Application for a Non-Material Amendment Following a Grant of Planning Permission

21/P/00312

On the planning consent drawings, 2 new front facing dormers are shown as having a flat roof. Permission is sought for these 2 dormers to have a pitched roof with external materials that together reflect the adjacent main gable elements of the enlarged house.

20-12 TP03A Proposed Plans and Elevations.

PROPOSED NORTH (front) ELEVATION

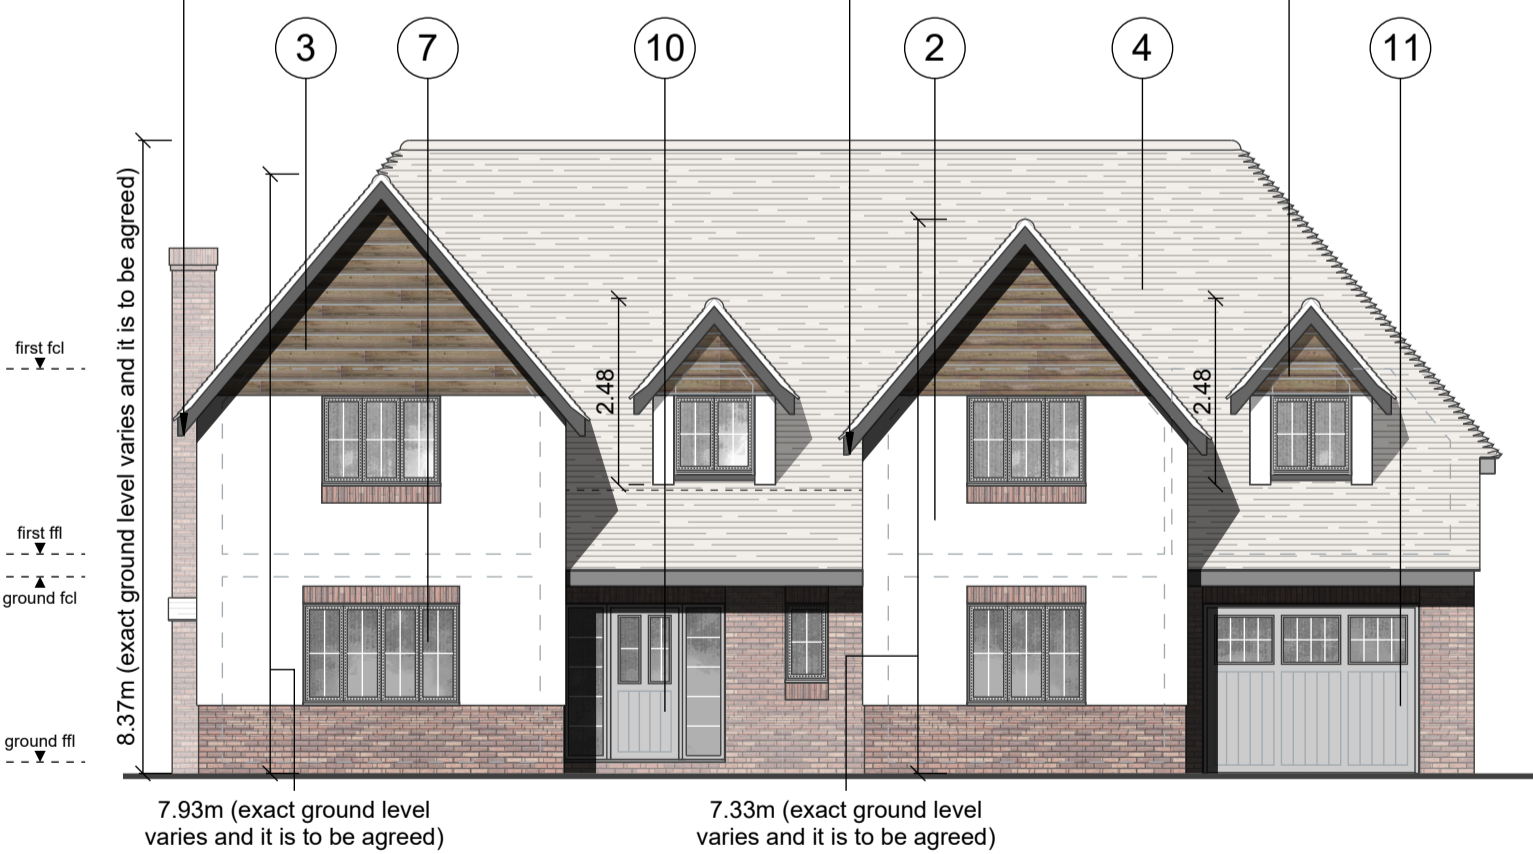
The proposed amendment to the roof form of the dormers and the associated variation in the external finishes aims to provide visual continuity between the different parts of the front elevation.
